# WISWELL PARISH COUNCIL

**Planning Application No: 3/2012/0483**  
**Proposed demolition of garage and stable buildings and replacement with garage building linked to house via glazed porch**  
**Pepper Hill, Pendleton Road, Wiswell, Lancashire, BB7 9BZ**

Drawing Title
 Phase II Proposed Garage

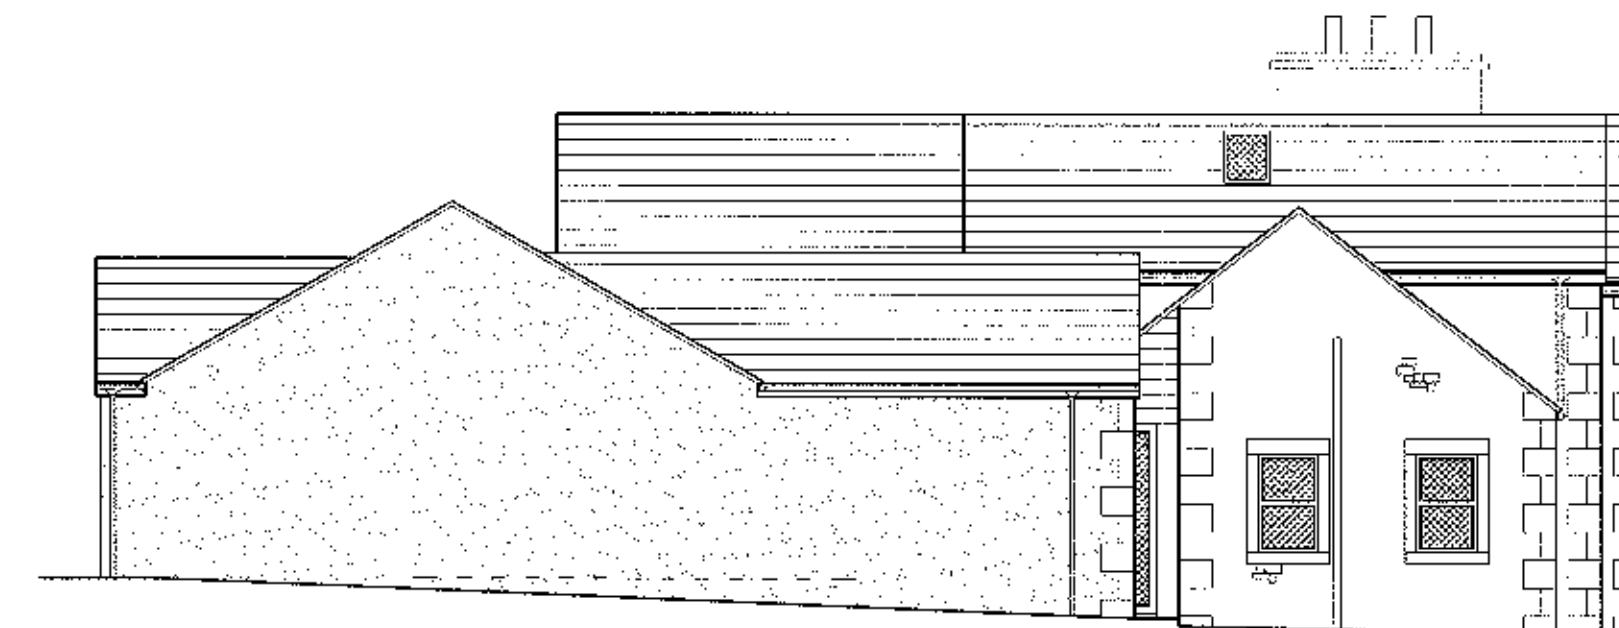
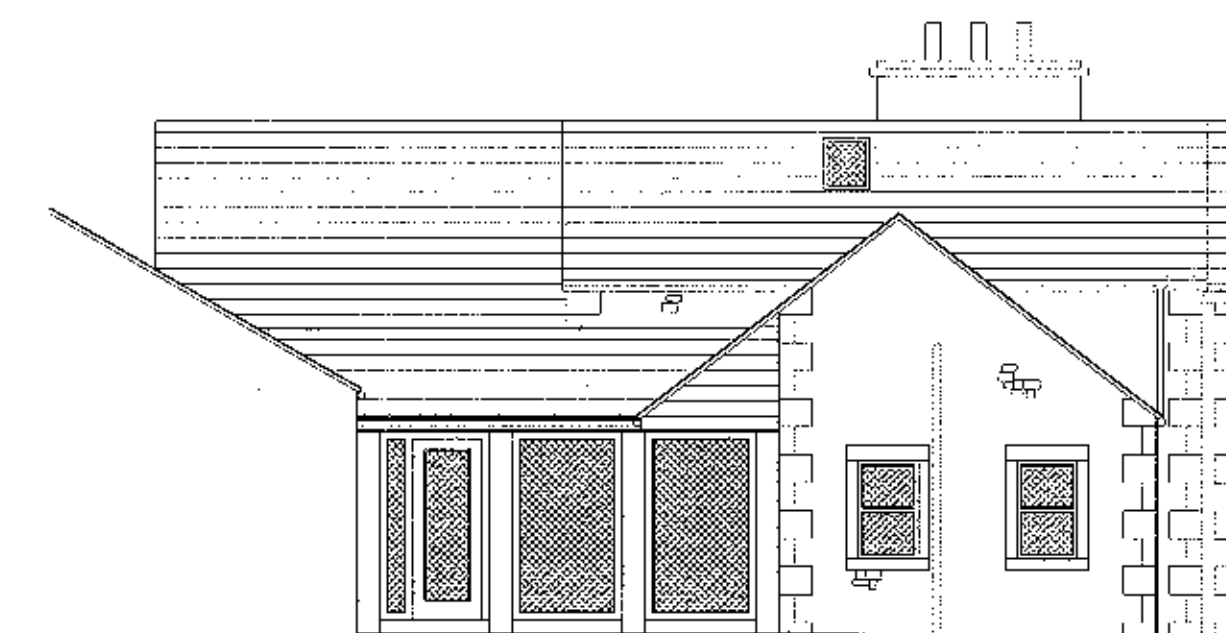
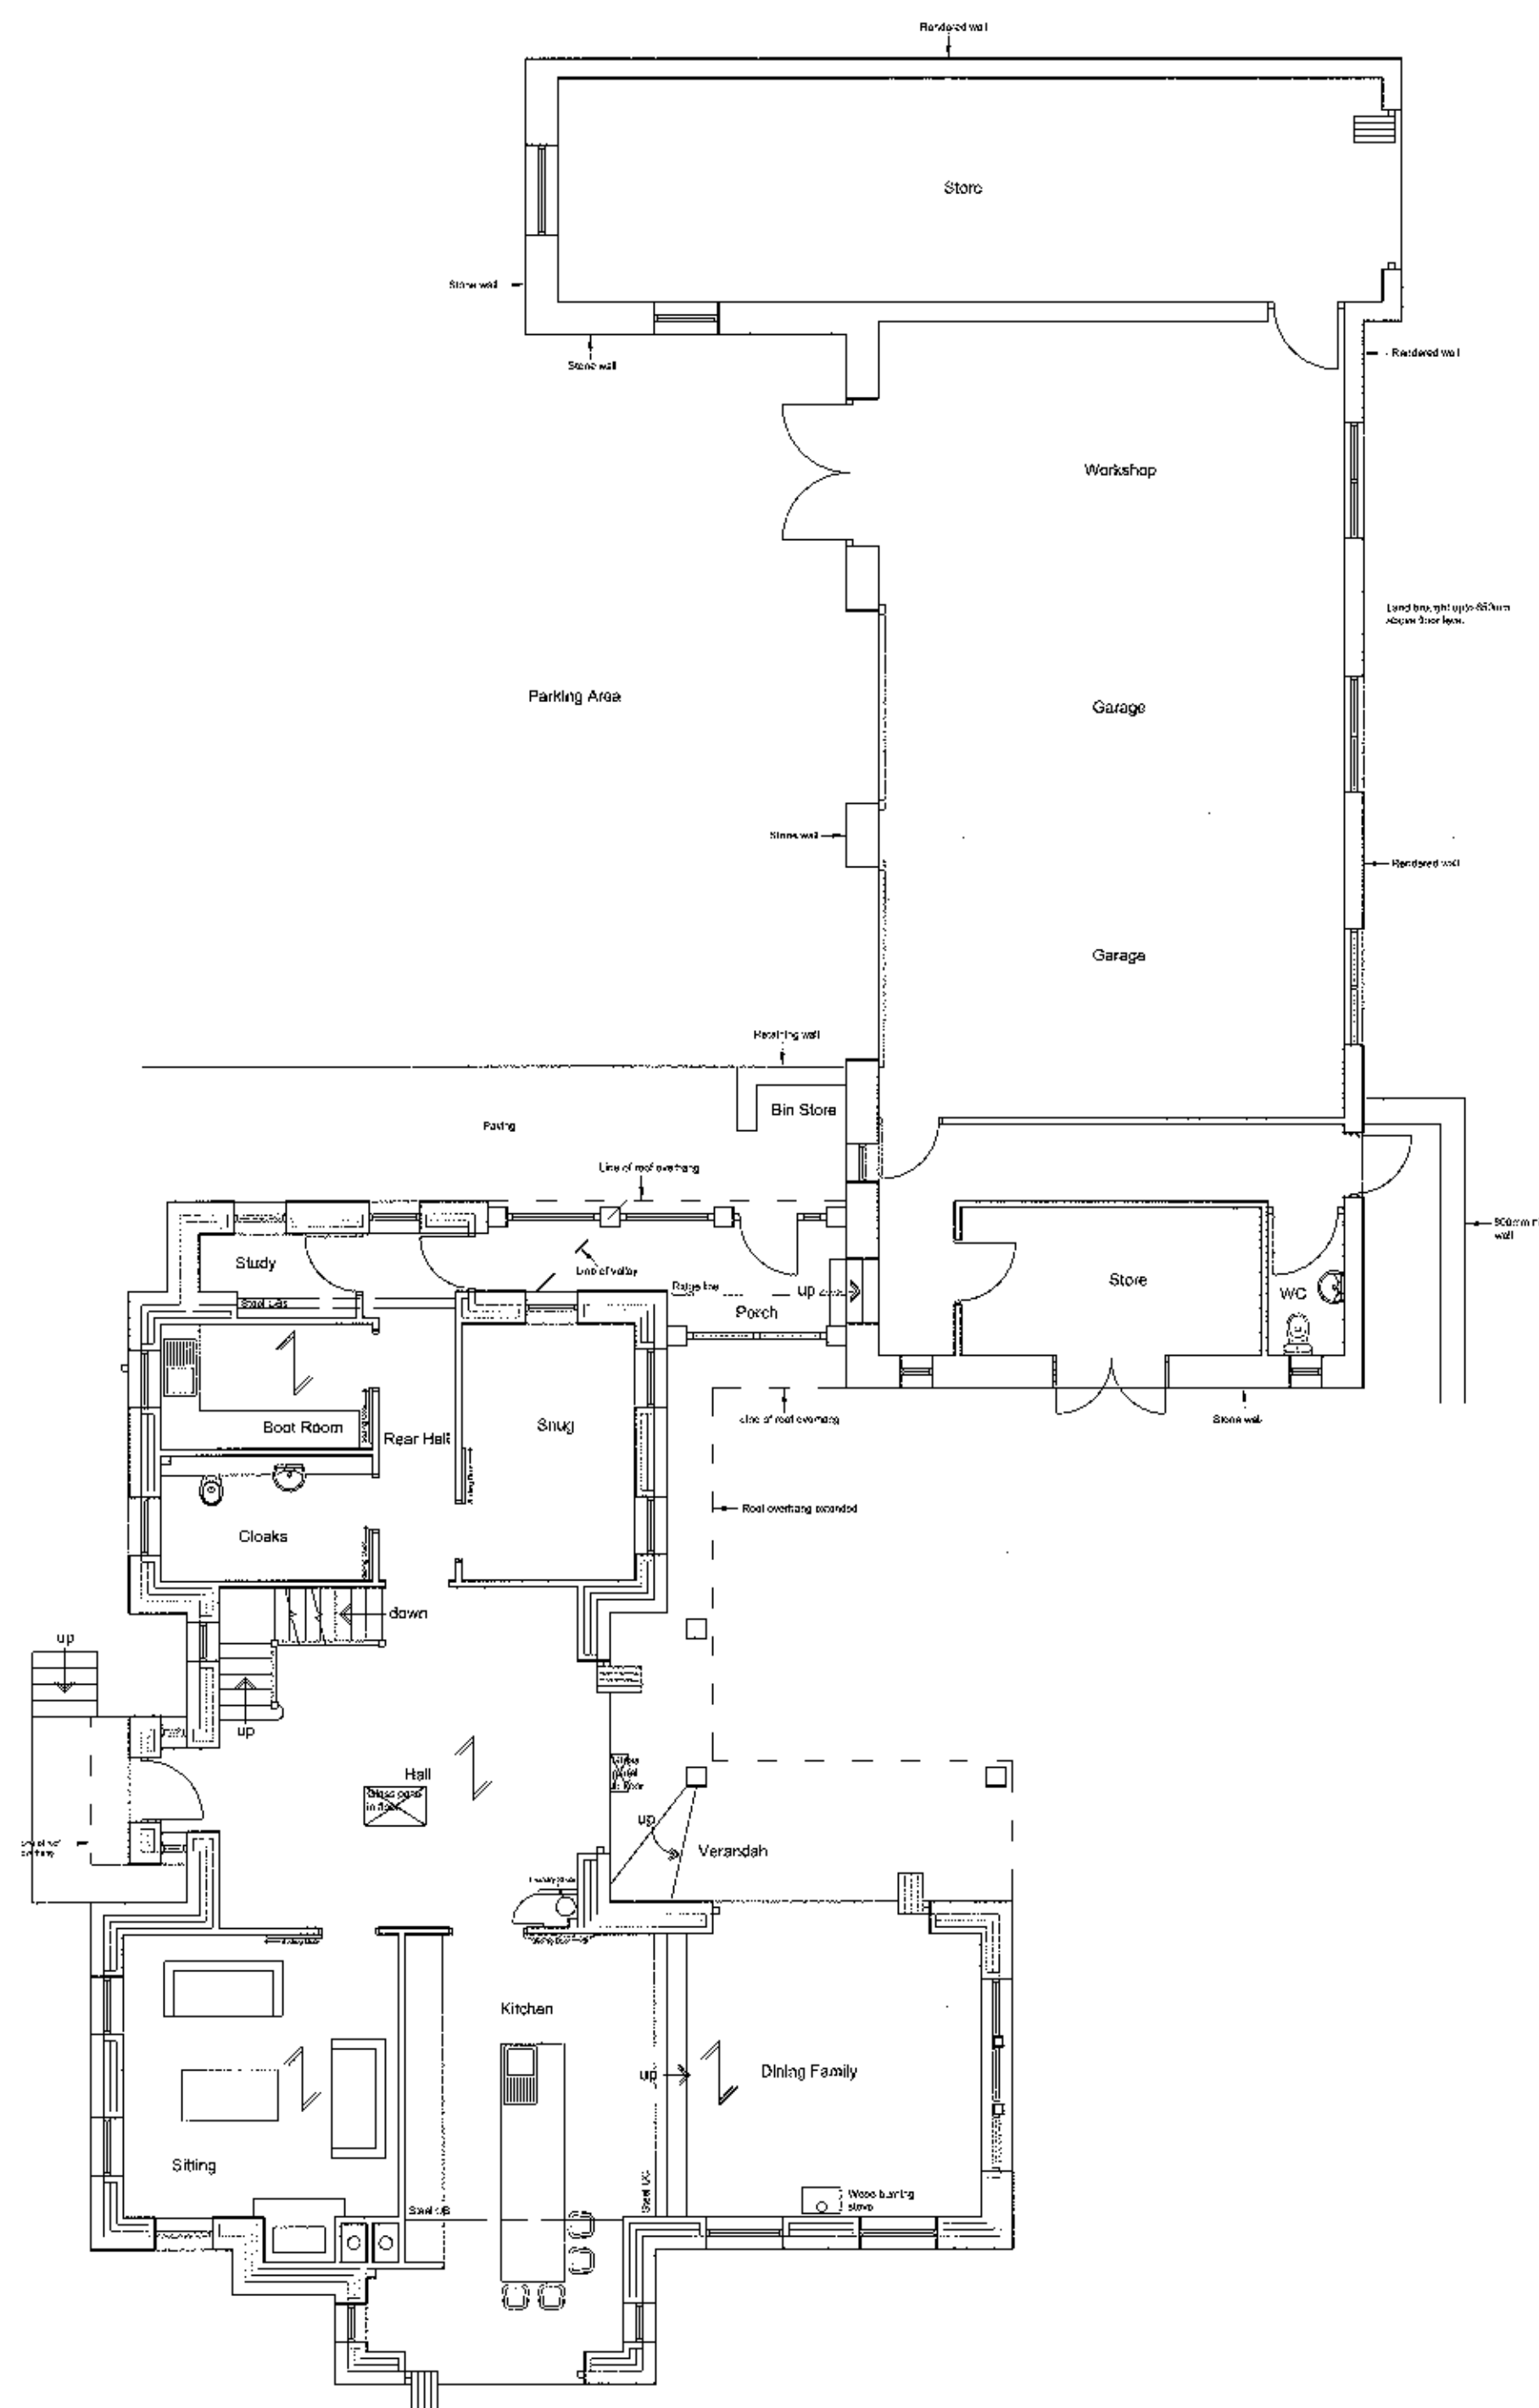
The above application has now been considered by the Parish Council. Members have observed that the length of the garage and ancillary building on the east side is disproportionate to the approved replacement dwelling and they consider this detrimental to the street scene.
